DOC18/199953-01
SSD 8778

**SSD 8778 – GREYSTANES PUBLIC SCHOOL RE-DEVELOPMENT – ENVIRONMENTAL
IMPACT STATEMENT (EIS)**

- ENVIRONMENT PROTECTION AUTHORITY COMMENTS -

GREYSTANES PUBLIC SCHOOL RE-DEVELOPMENT

Appendix B Daily noise survey data

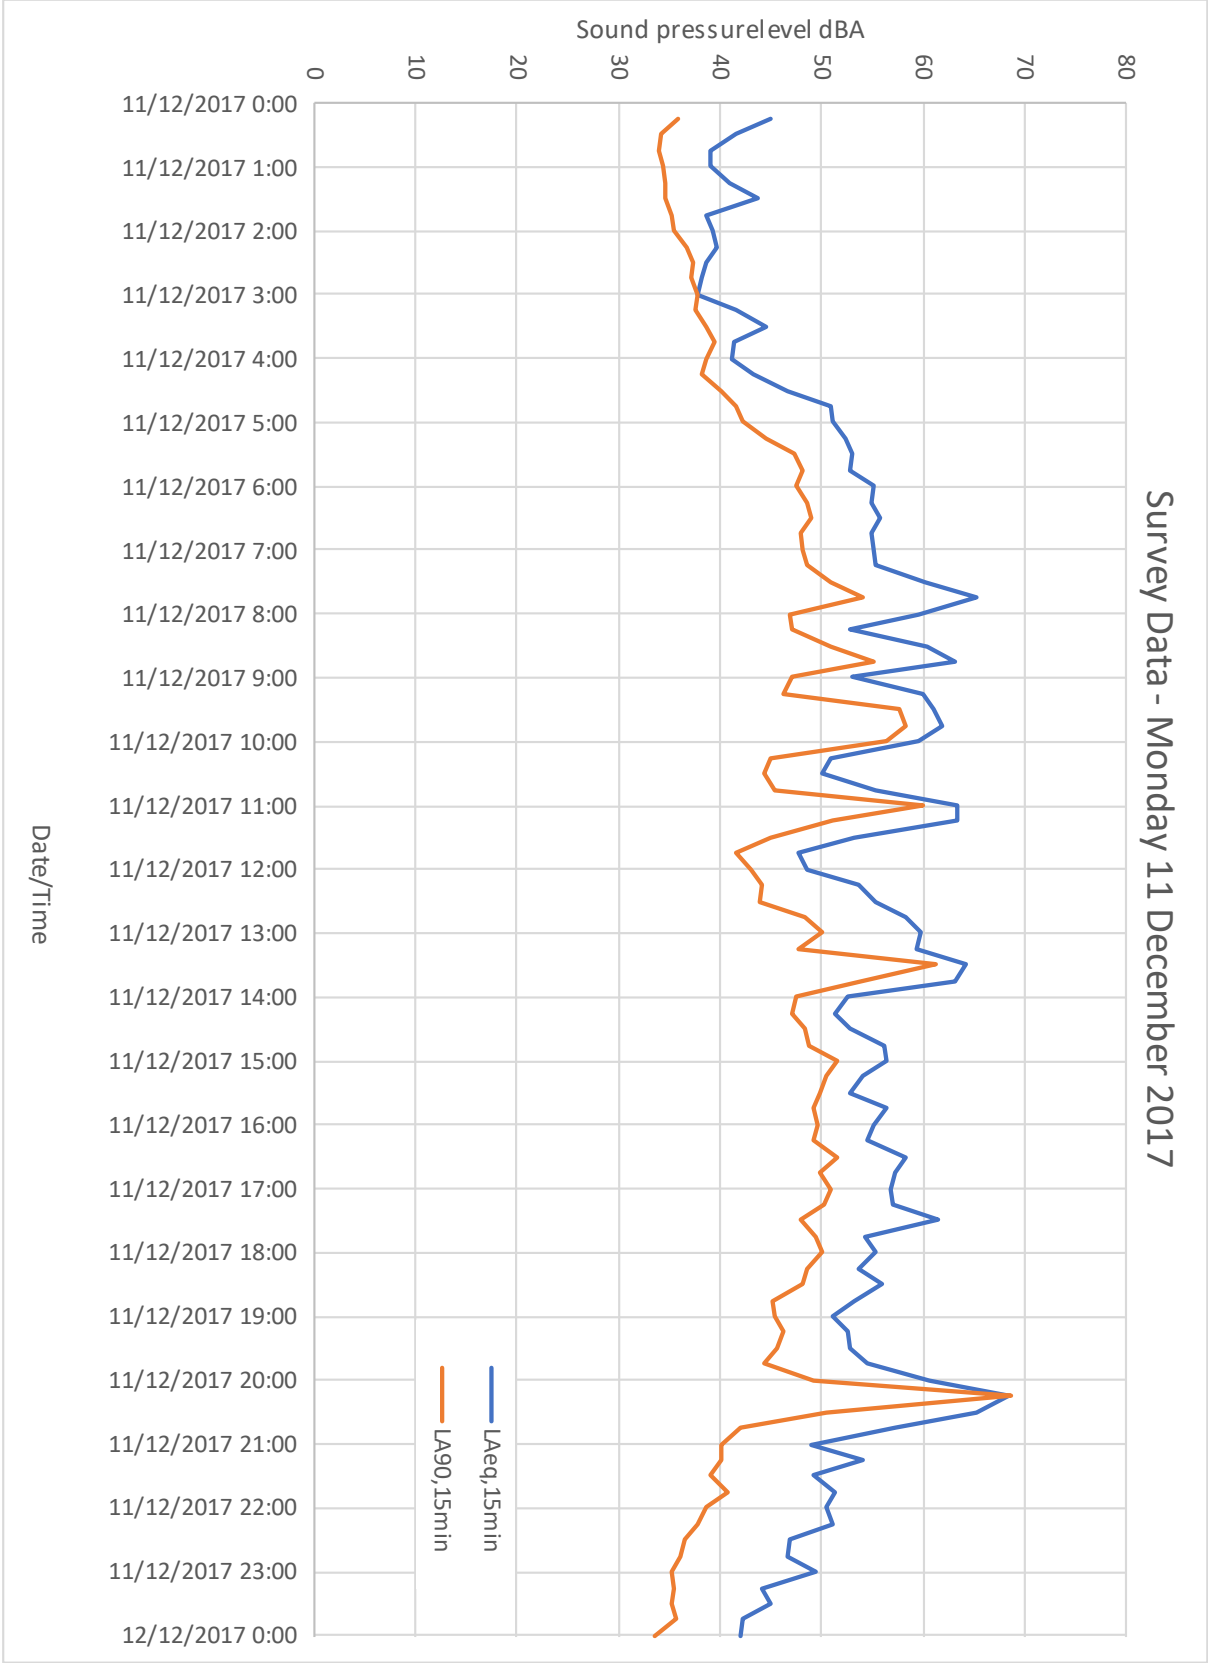
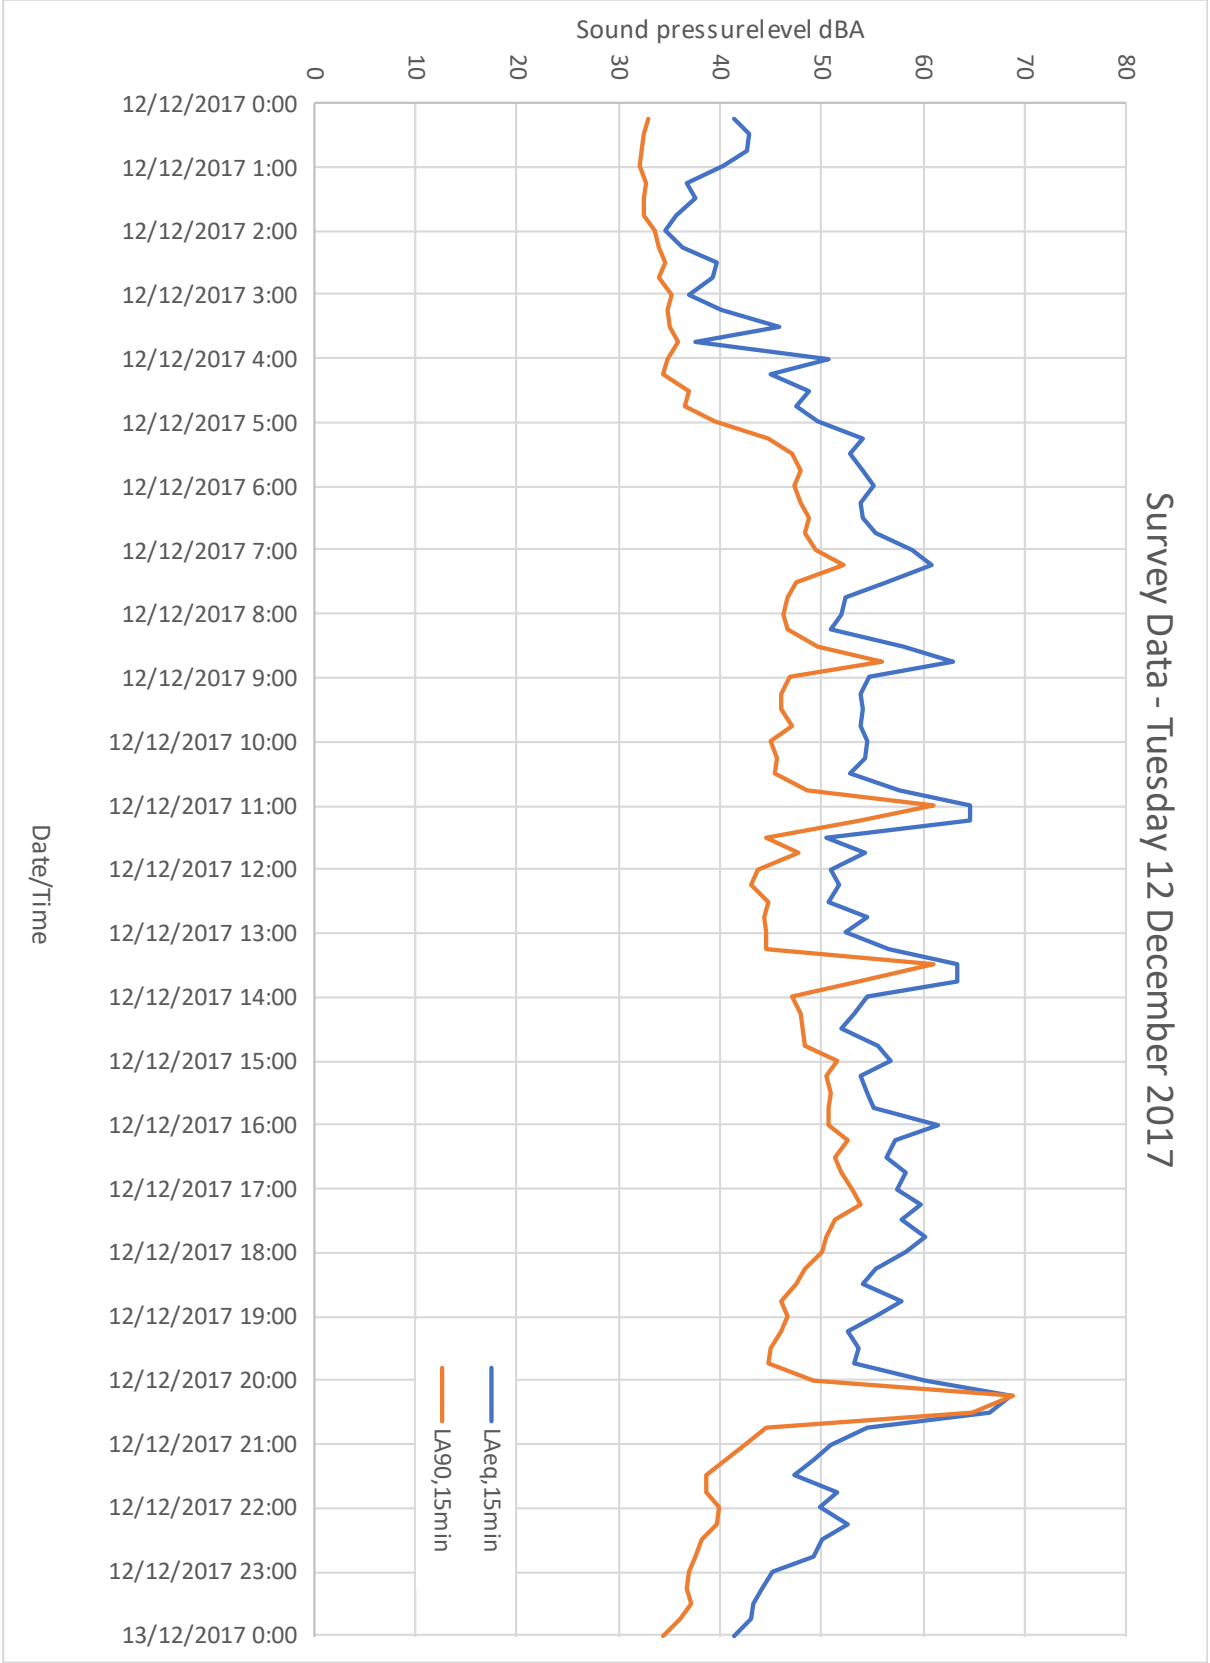
The EPA further notes that graphical presentations in Appendix B (to EIS Appendix 14) clearly show that the December 2017 background noise monitoring results are affected by a specific source or sources (extraneous noise) at specific times of the days. Importantly, those effects are not considered in Appendix 14.

The EPA recommends DPE require the proponent to establish background noise levels in accordance with the requirements of the INP.

The proponent be required to properly establish the background noise level for the locality for each assessment period (i.e. day, evening, night) in accordance with the guidance provided in the New South Wales Industrial Noise Policy.
